City of Portland, Maine - Building or Use Permit

Permit No: 2013-00834	Date Applied For: 04/26/2013	CBL: 015 C001001
---------------------------------	--	----------------------------

Location of Construction: 294 EASTERN PROMENADE	Owner Name: ASHBY TEAM REALTY LLC	Owner Address: PO BOX 3793	Phone: (207) 797-0000
Business Name:	Contractor Name: Quality Design Pools	Contractor Address: 116 Perimeter Road Unit K Nashua	Phone: (603) 880-4888
Lessee/Buyer's Name	Phone:	Permit Type: Pool - In Ground

Proposed Use: Same: two residential family dwelling units	Proposed Project Description: Install a inground 18' x 36' Pool Mountain Lake Style
---	---

# QUALITY DESIGN POOLS

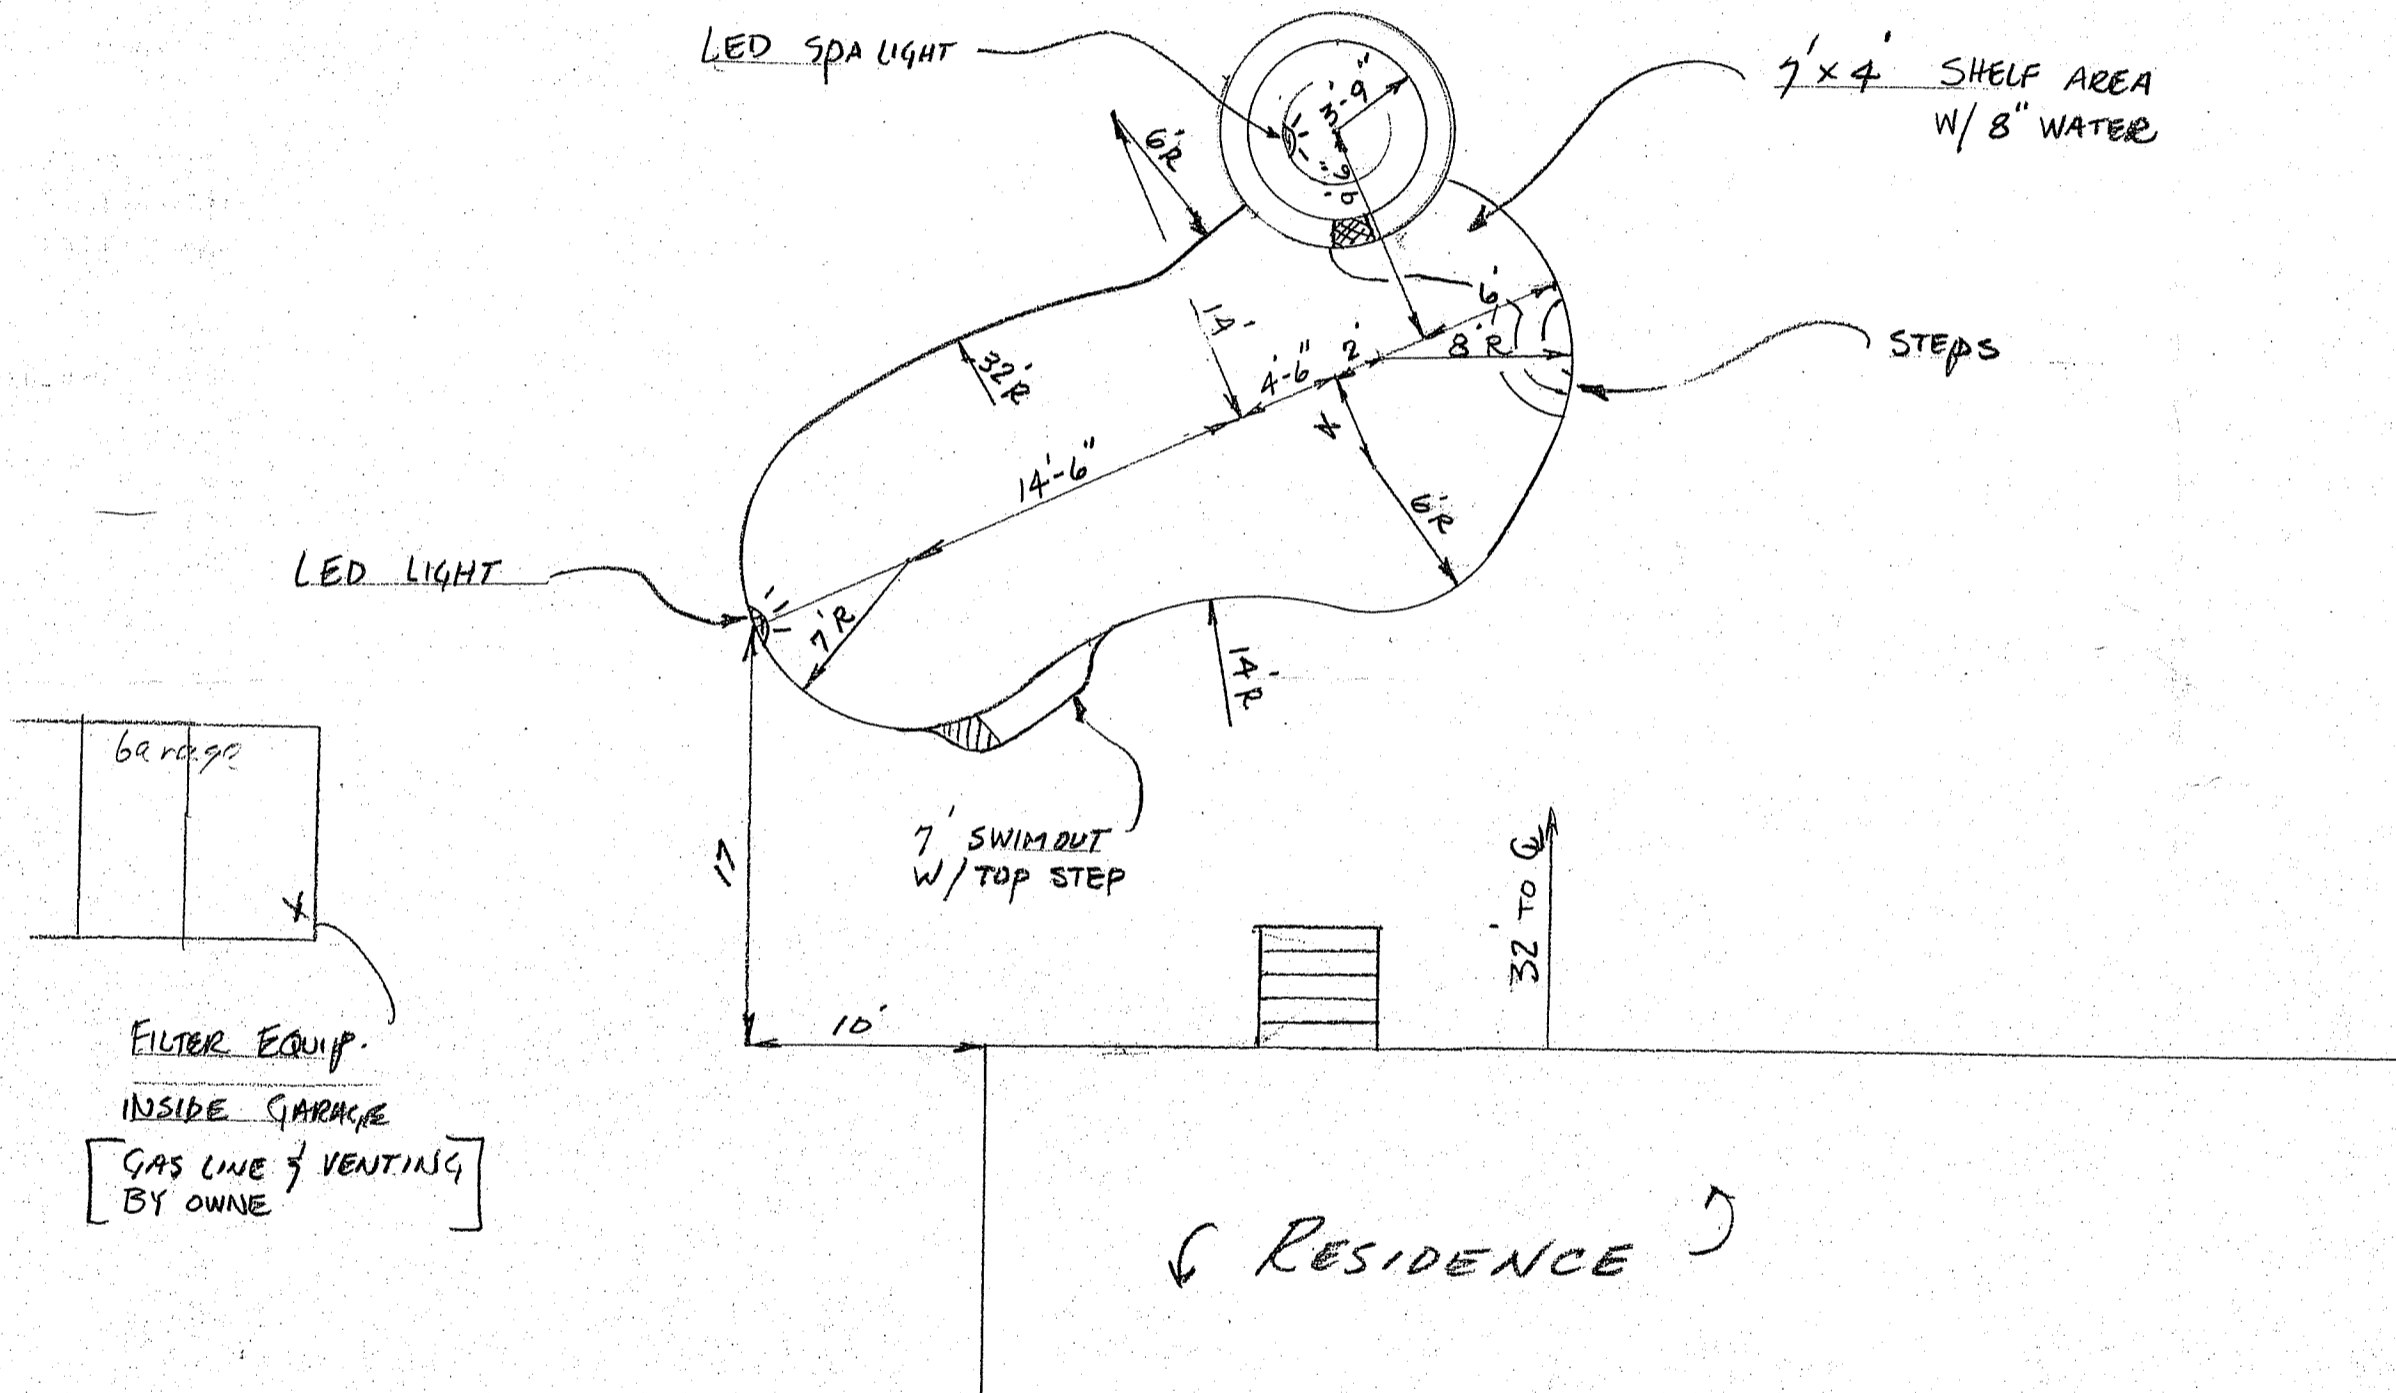
- 2) Pool electrical requirements shall comply with Article 680 of the NEC, 2011.
- 3) The top of the barrier shall be at least 48 inches above grade measured on the side of the barrier which faces away from the swimming pool. The maximum vertical clearance between grade and the bottom of the barrier shall be 2 inches on the side of the barrier which faces away from the swimming pool. Where the top of the pool structure is above grade, such as an aboveground pool, the barrier may be at ground level, such as the pool structure, or mounted on top of the pool structure. Where the barrier is mounted on top of the pool structure, the maximum vertical clearance between the top of the pool structure and the bottom of the barrier shall be 4 inches.

Openings in the barrier shall not allow passage of a 4-inch-diameter sphere.

Self-latching access gates shall comply with the standards in Section 6-24 of the City of Portland Buildings and Building Regulations, and shall be equipped to accommodate a locking device.

SITE MAP

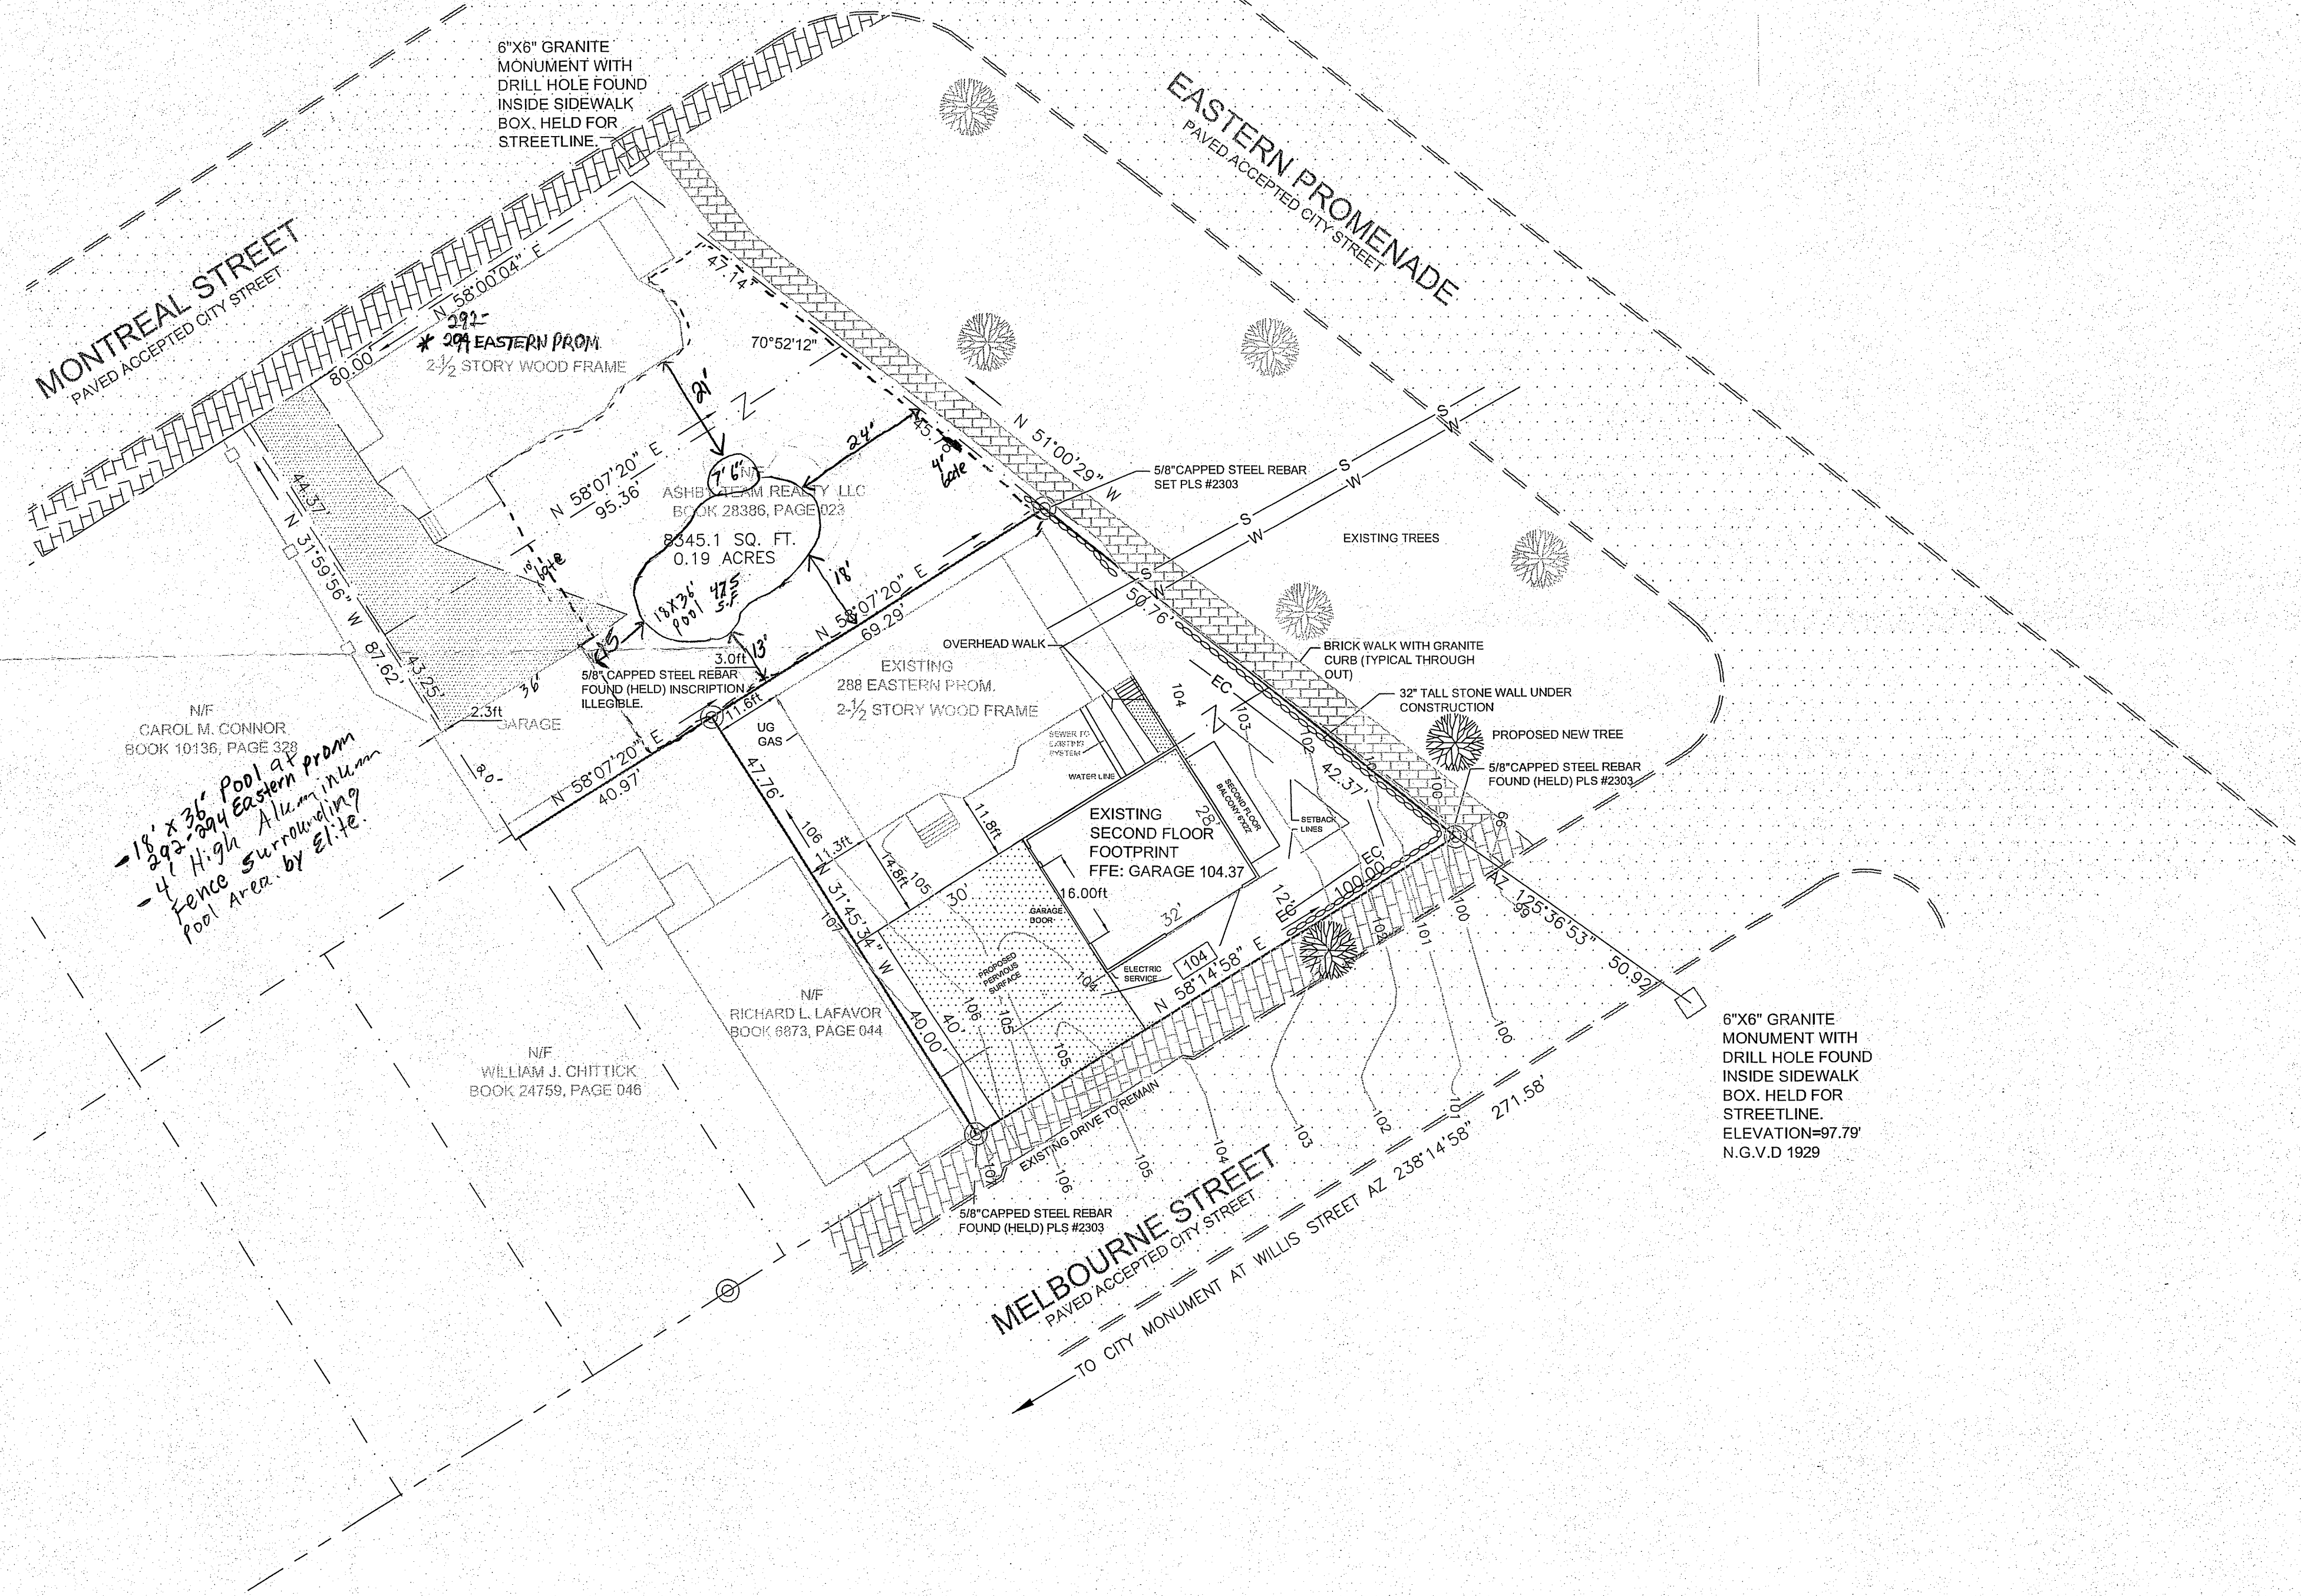
- 1) The proposed pool shall be no closer than 10' to rear and side property lines and also 10' from the principal structure.
- 2) This is NOT an approval for an additional dwelling unit. You SHALL NOT add any additional kitchen equipment including, but not limited to items such as stoves, microwaves, refrigerators, or kitchen sinks, etc. Without special approvals.
- 3) This property shall remain a two (2) family dwelling. Any change of use shall require a separate permit application for review and approval.
